Application No: AW/87/20/HH

Site Address: 2 Priory Close Aldwick West Sussex PO21 4HH

Description of works: Single storey front & rear extensions & detached outbuilding.

Thank you for your internet representation made on 7th May 2020 which has been recorded as an objection with the comments as follows:

PROPOSED DETACHED OUTBUILDING AT 2, PRIORY CLOSE, ALDWICK BAY
FOR MR. & MRS. A. MARTIN.

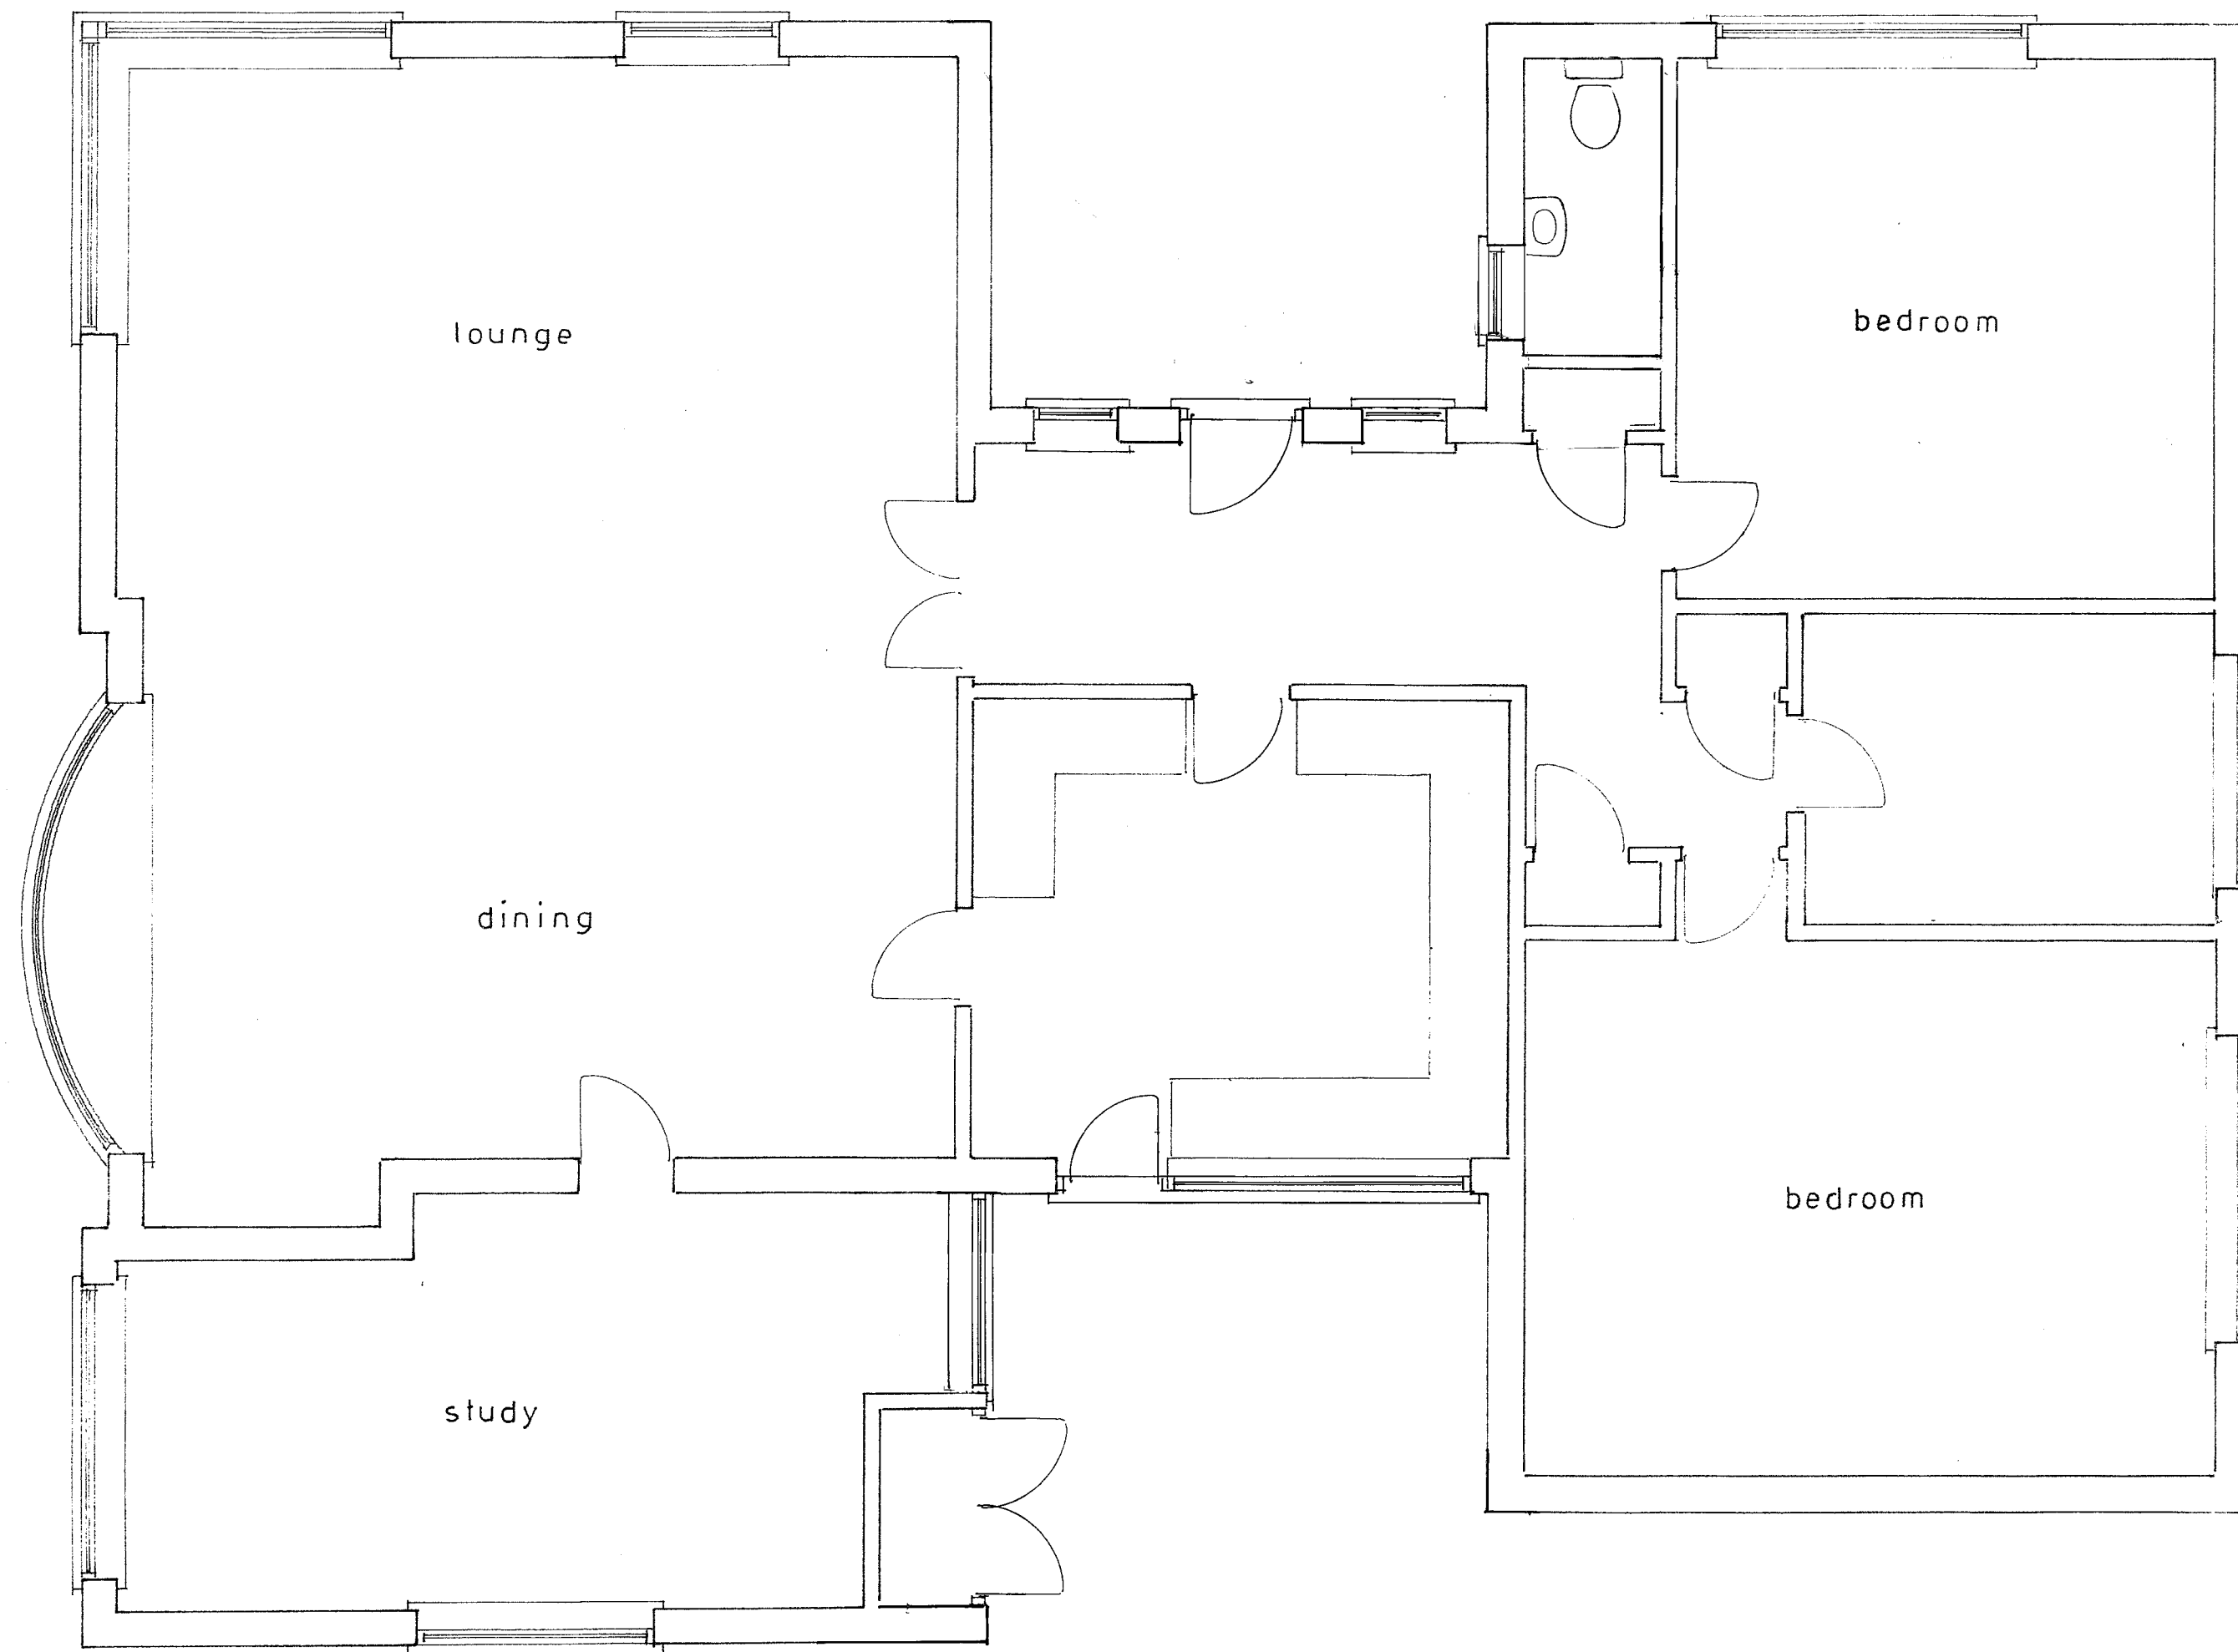
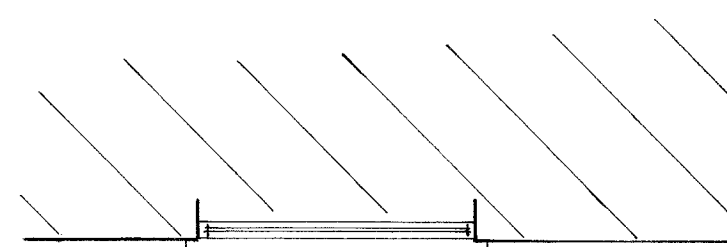
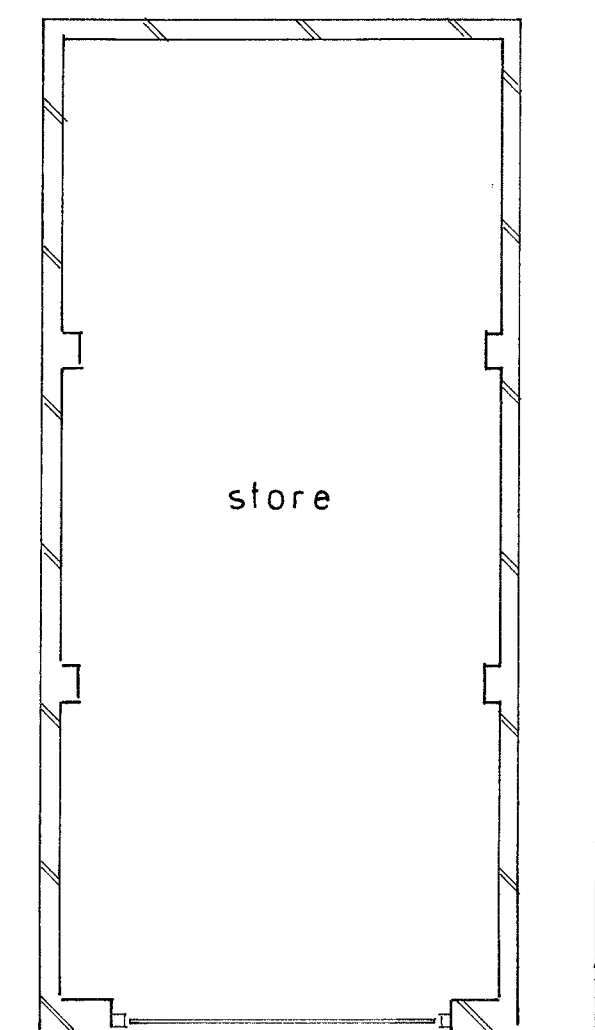
The outbuilding is a concern.

Whilst the proposed construction from matching materials is appropriate, I am concerned that the view from Priory Close will be compromised by a large building that is out of keeping with the surrounding area. I can not see from the application what the height of the building will be.

The proposed structure has no precedent in the nearby neighbourhood, I believe, and I would like to be assured as to its use (ie no workshop/business use and no dwelling use.) There would appear to be a potential attraction to the owner in gaining road access from Priory Close, or possibly from Regis Avenue, and I would like to be assured that this is not part of any permission.
